Our ref: XA/2025/100270/04-L01

Date: 7 October 2025

ISSUE SPECIFIC HEARING 2 (ISH2) INTO ENVIRONMENTAL MATTERS

BOTLEY WEST SOLAR FARM, OXFORDSHIRE

Illustrative Masterplan
Figure 5.5D: Cable Corridor Option D

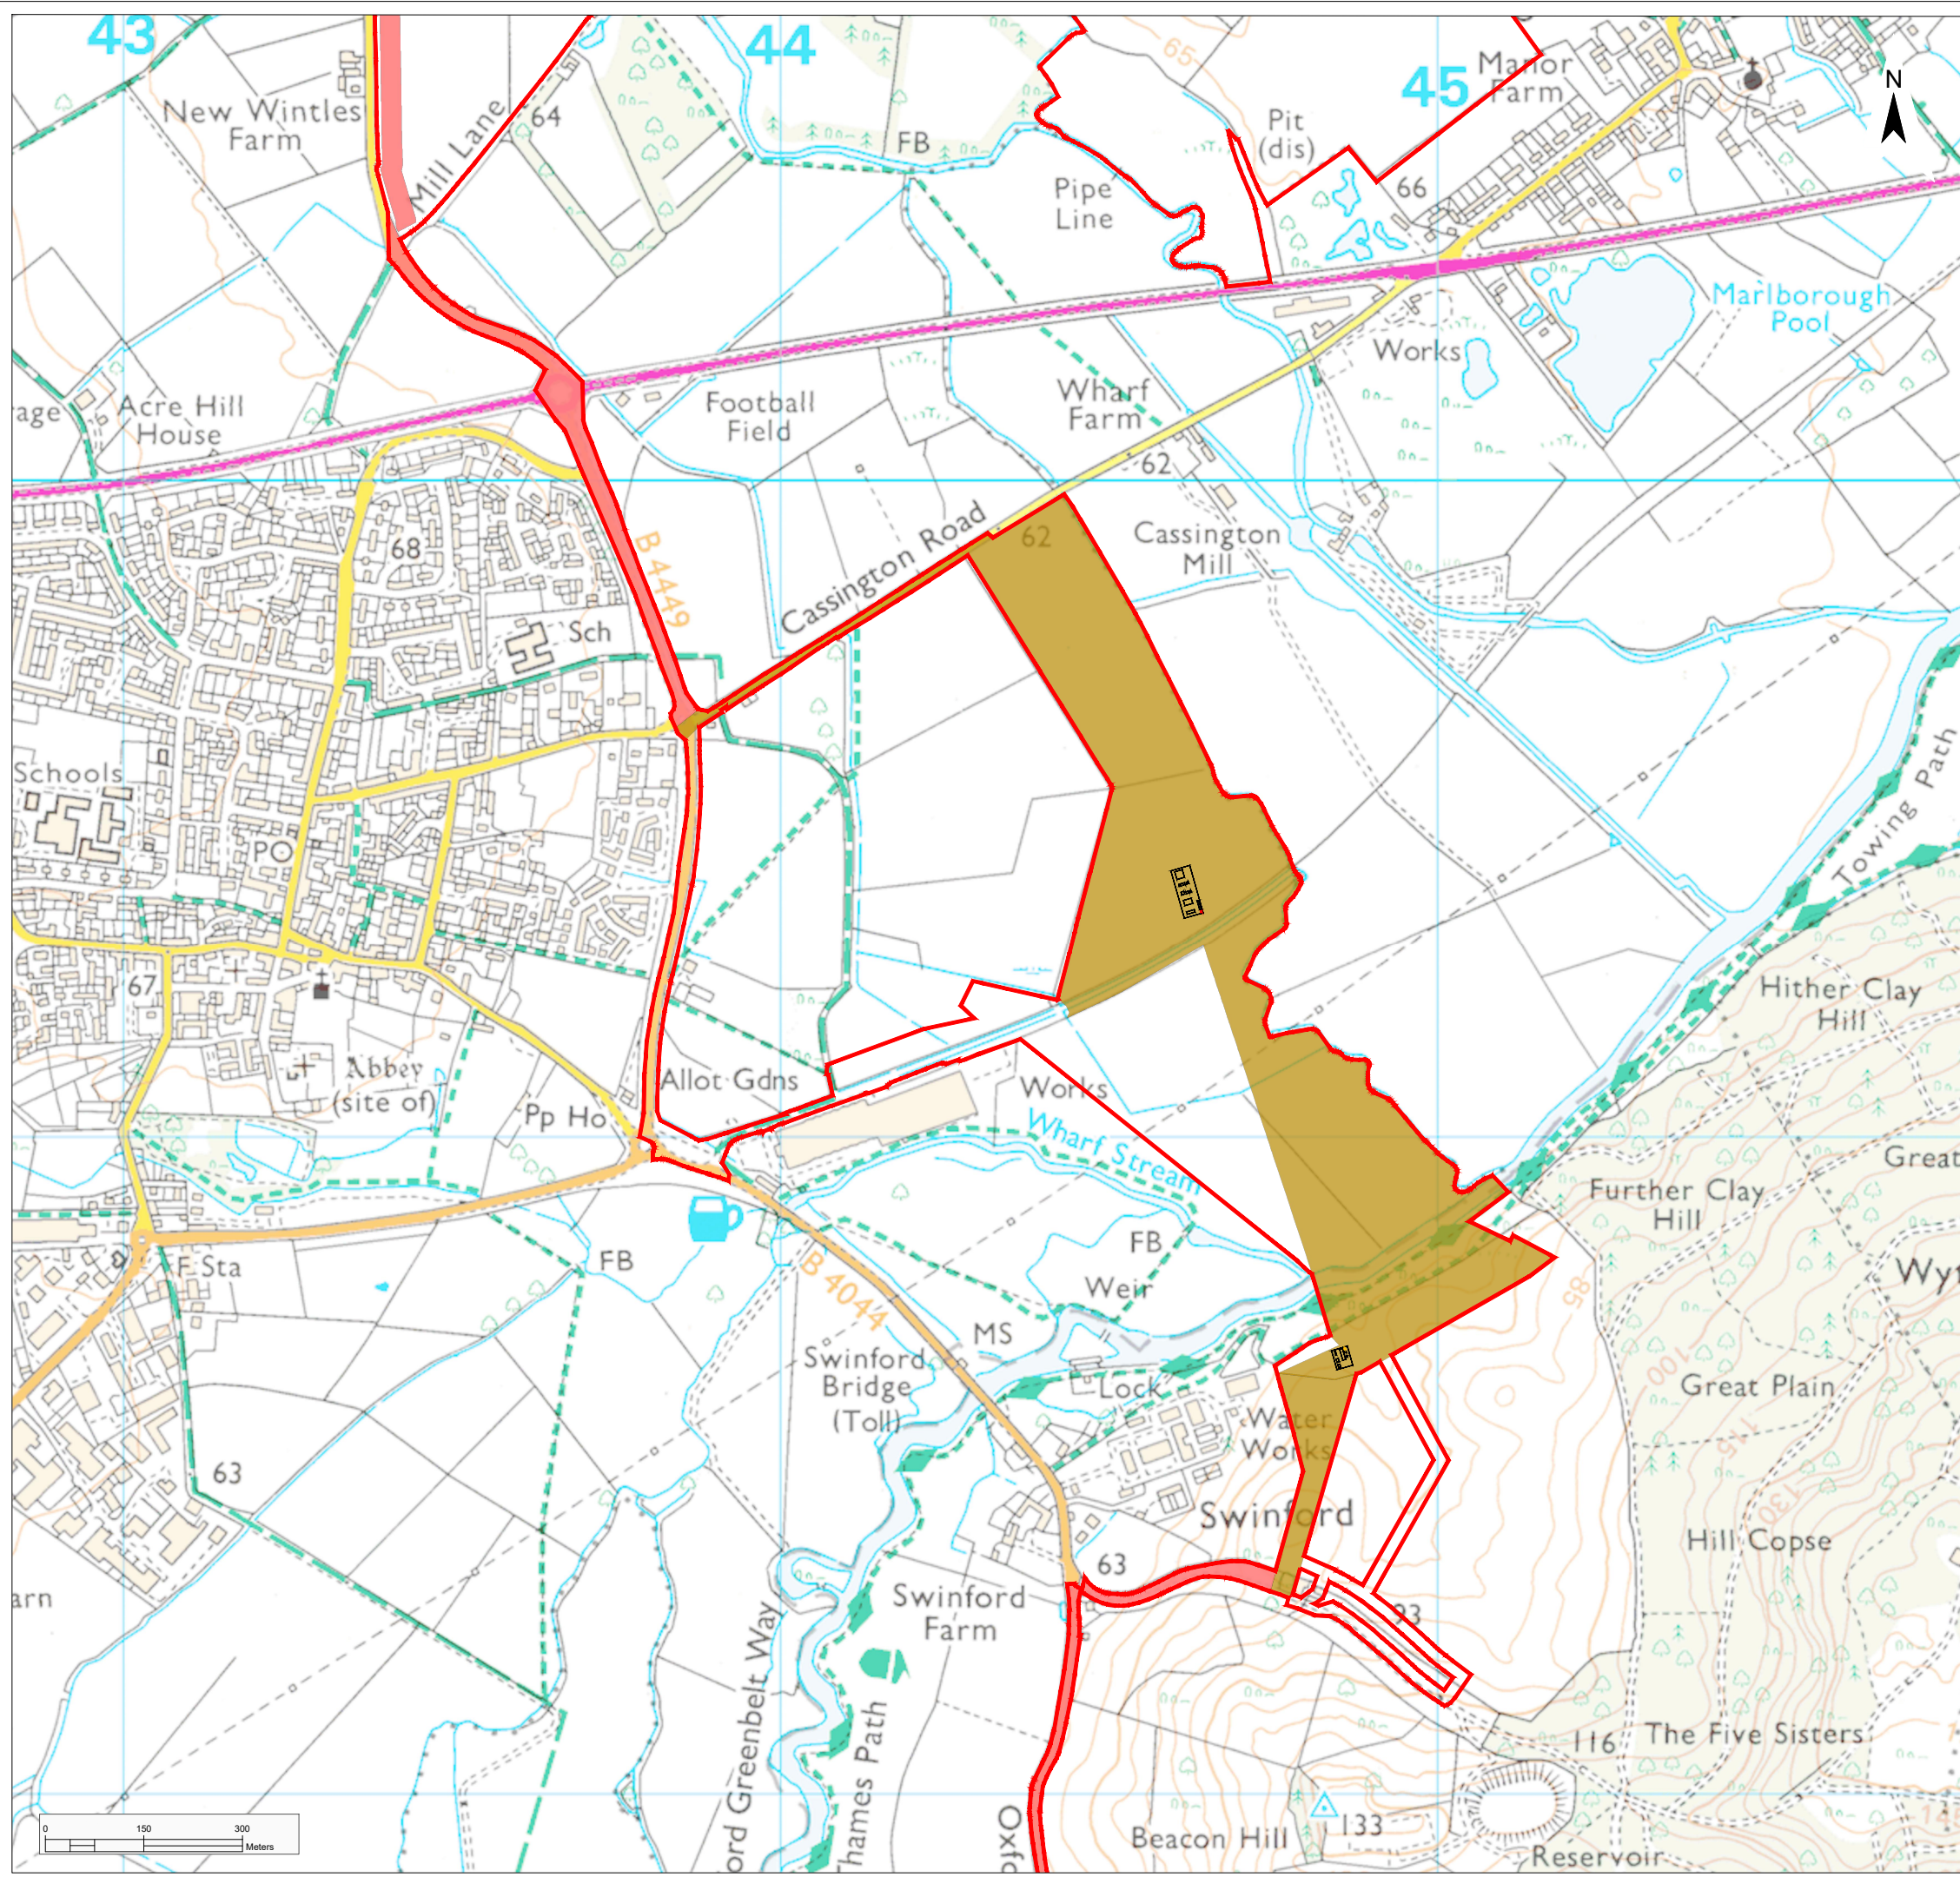
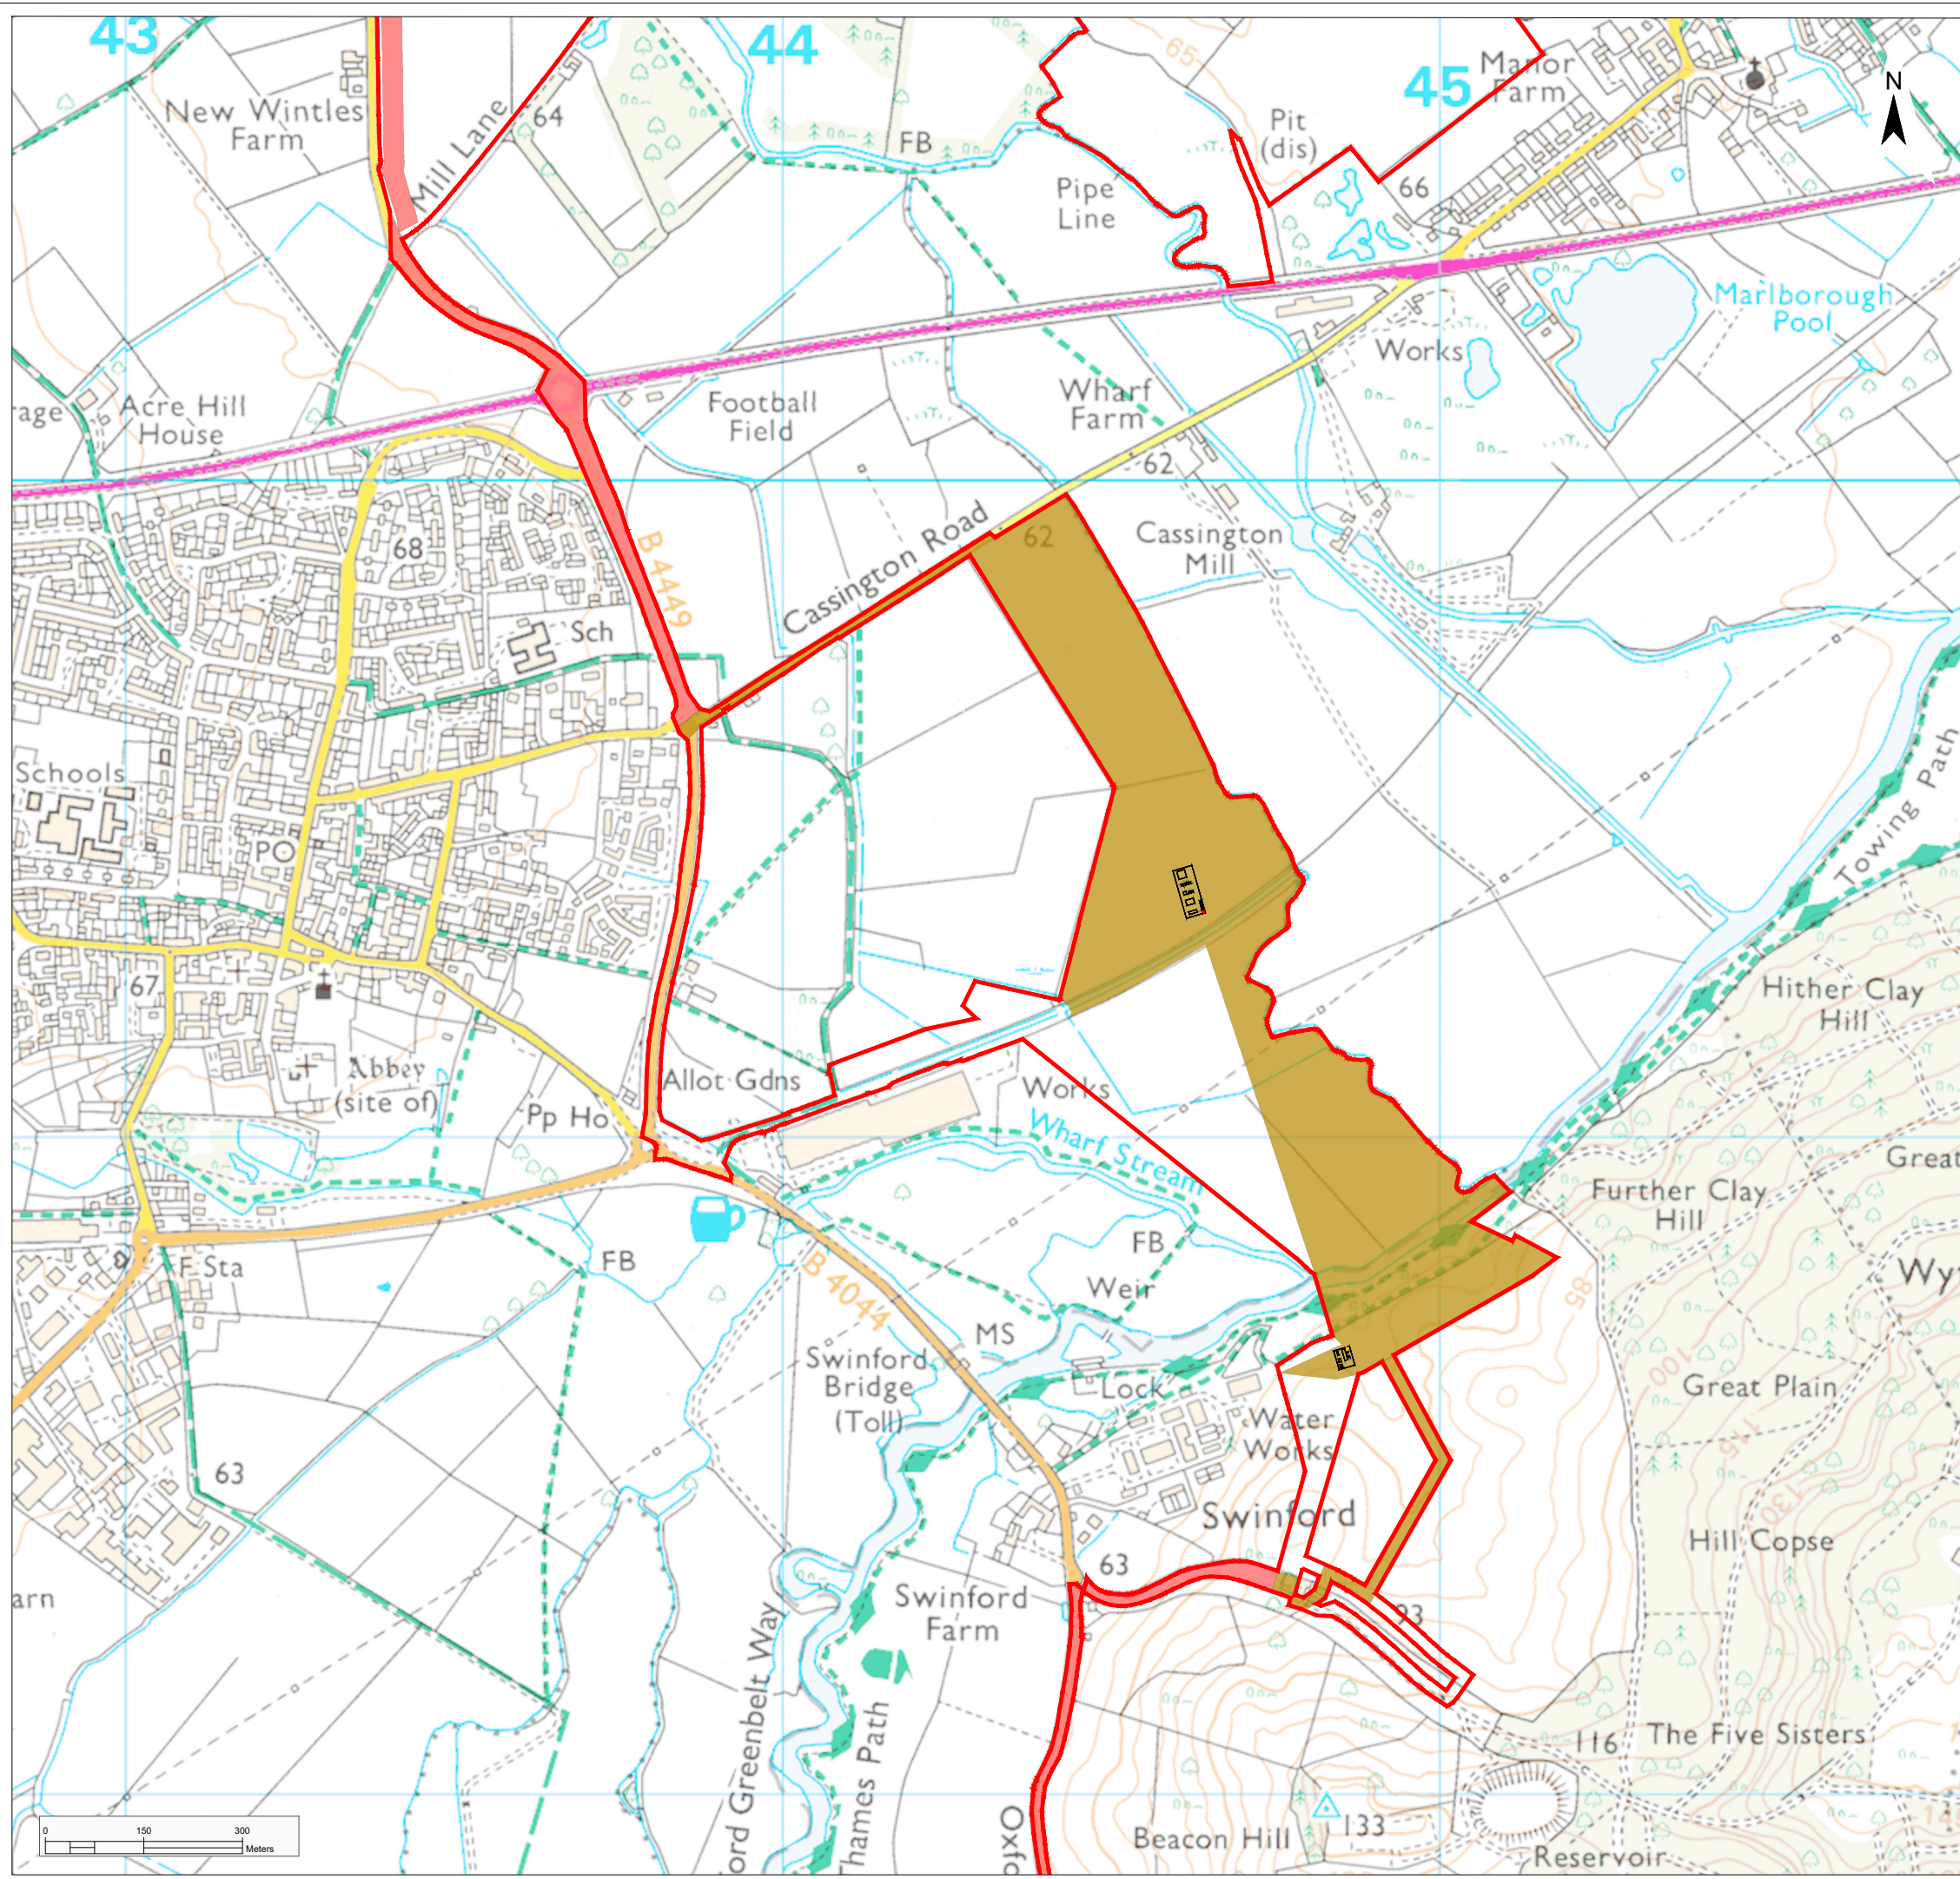
Flood Zones 3a and 3b / ES, FRA	EAFR-009 – Provide mapping that shows Flood Zones 3a and 3b with proposed components and the cable corridor route. Minimise interaction with Flood Zone 3b.					<p>The Swinford HDD entrance pits are shown to be within the extent of Flood Zone 3b within the West Oxfordshire Strategic Flood Risk Assessment. The latest Risk of Flood from Rivers and Sea (RoFRS) dataset shows the chance of flooding from rivers and the sea considering the presence and condition of flood defences. The Swinford HDD entrance pits are at a high-risk classification based on this dataset. A high-risk classification has a greater than or equal to 1 in 30 (3.3%) chance of flooding in any year. I would suggest using the Risk of Flooding from Rivers and Sea dataset for informing the risk to the entrance pits rather than solely the outlines from the River Thames as the RoFRS dataset will incorporate the risk from other watercourses as well such as the lower River Evenlode. In addition to the modelled outlines, the Swinford HDD crossing entrance pits are also shown to be within the Winter 2013/14 recorded flood extent, January 2003 recorded flood extent, and the Winter 2000 recorded flood extent. Given the location of the entrance pits within a high-risk flood area, there is also potential for flood flow routes through the HDD tunnel to the opposite bank of the Thames. The applicant should assess this risk and clearly outline the mitigation measures.</p> <p>The applicant will need to review this with respect to the Swinford HDD entrance pit and provide written justification as to why the entrance pit cannot be moved outside of functional floodplain. In such cases,</p>

<p>appropriate mitigation measures must be presented to manage and reduce flood risk. It is important to note that mitigation measures may remain relevant even if the HDD entrance and exit pits are located within Flood Zone 3a, as this is still an area at risk of flooding.</p>
--	--	--	--	--	--	--	--	---
